From: Farhad Aarabi <[REDACTED]>
Sent: 26 October 2014 20:12
To: Daun Johnson
Subject: RE: Further Information Required on Your Ref: PP-03642150 Our Ref: BR/239/14/A

Proposed Advertisement

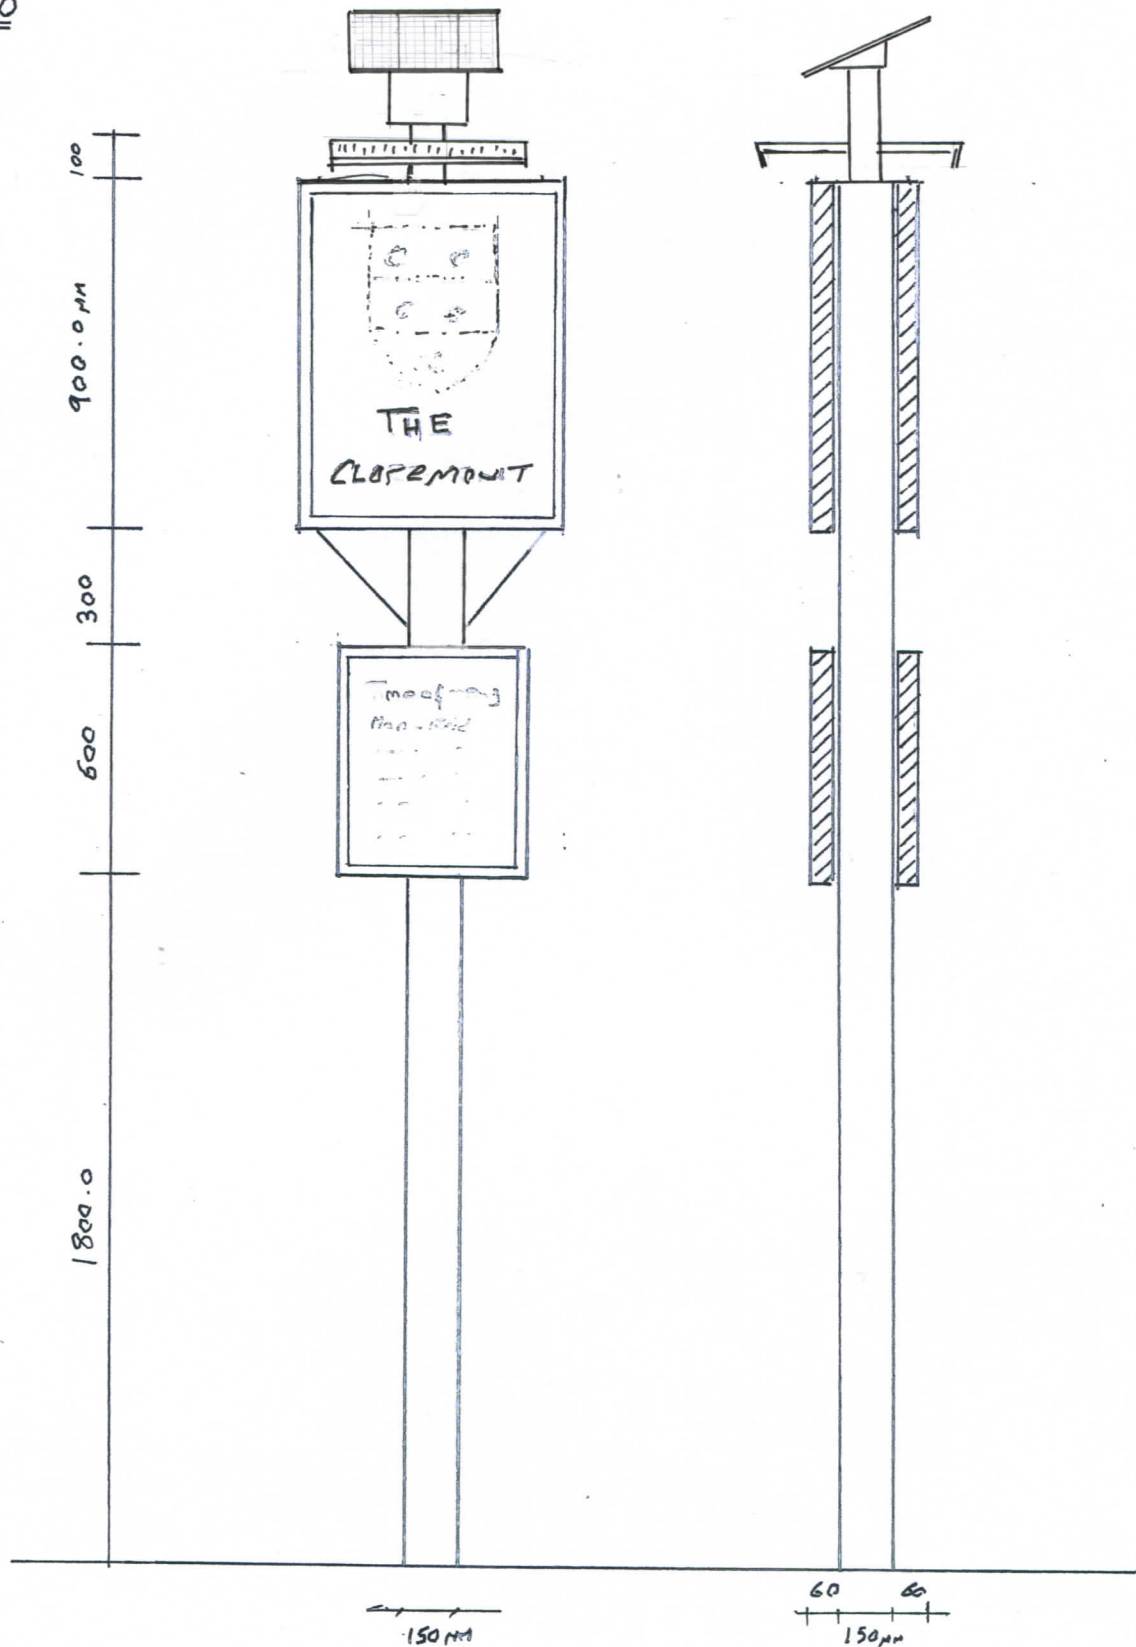
I have found information you have provided by email that the sign is to be illuminated using solar panel energy system.

I only need some manufacturer details about the solar panel.

- The proposed sign will be illuminated using solar panel system.
- The proposed solar power sign is designed to run all year round, often running more in winter when there is less light.

The proposed solar panel sign will be of modern light efficiency solar powered and has a zero carbon foot print-reducing pollution and improving sustainability.

The solar power assemblies attach separately from the light fixture or powered device.

The solar array slides directly on to the power brackets and contain the battery assembly cover.

The marine grade aluminium box contains the battery, the charge/ load computer and any other control electronics specified.

The aluminium power brackets flip over to provide 5, 15, or 45 degree solar array.

Block Plan
Scale 1:500

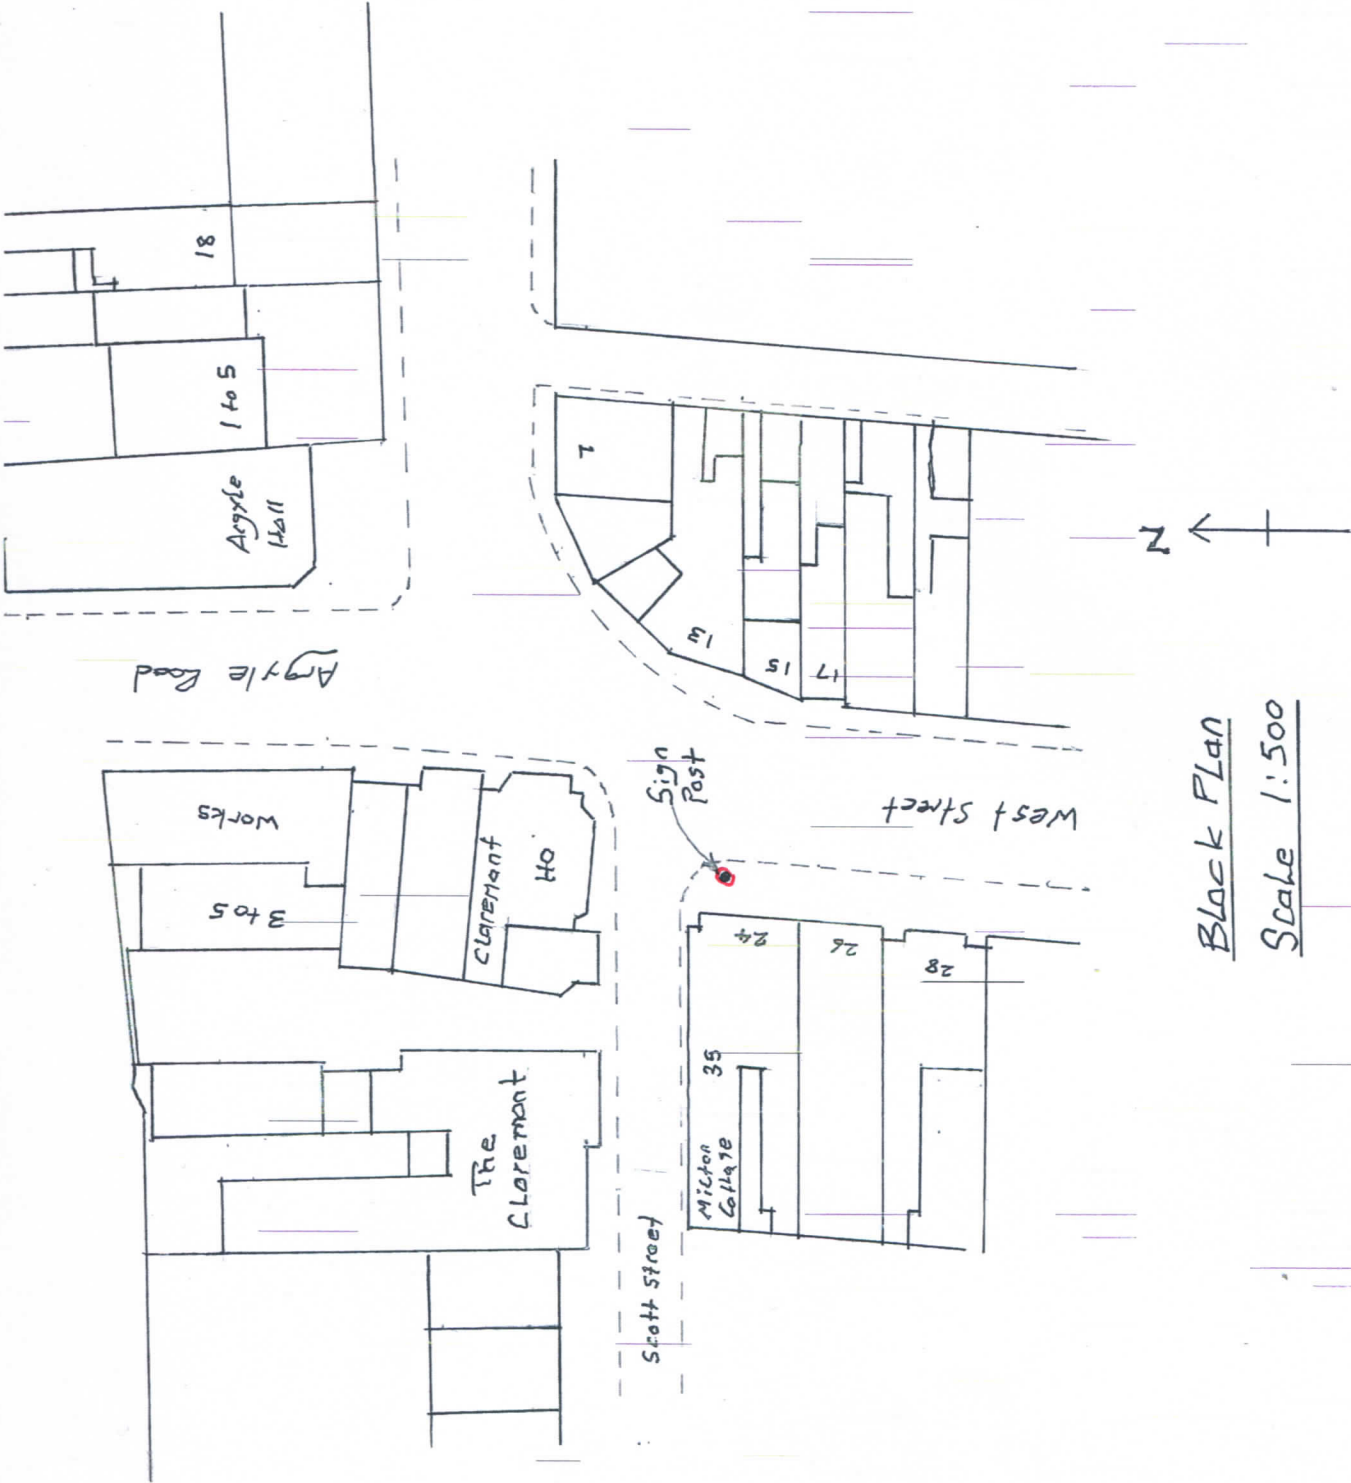
I have been on leave, returning this morning.
I have noticed that the block plan on the above application has The Claremont edged in red.
Please take the red edge off of just The Claremont and return to me by email.

On the block plan, can you please indicate the position of the sign post? Currently, the block plan is showing the sign post in front of 24 West Street and not the Claremont.

The position shown on the block plan is correct, my client thinks the public will notice the sign more if it is situated in West Street.
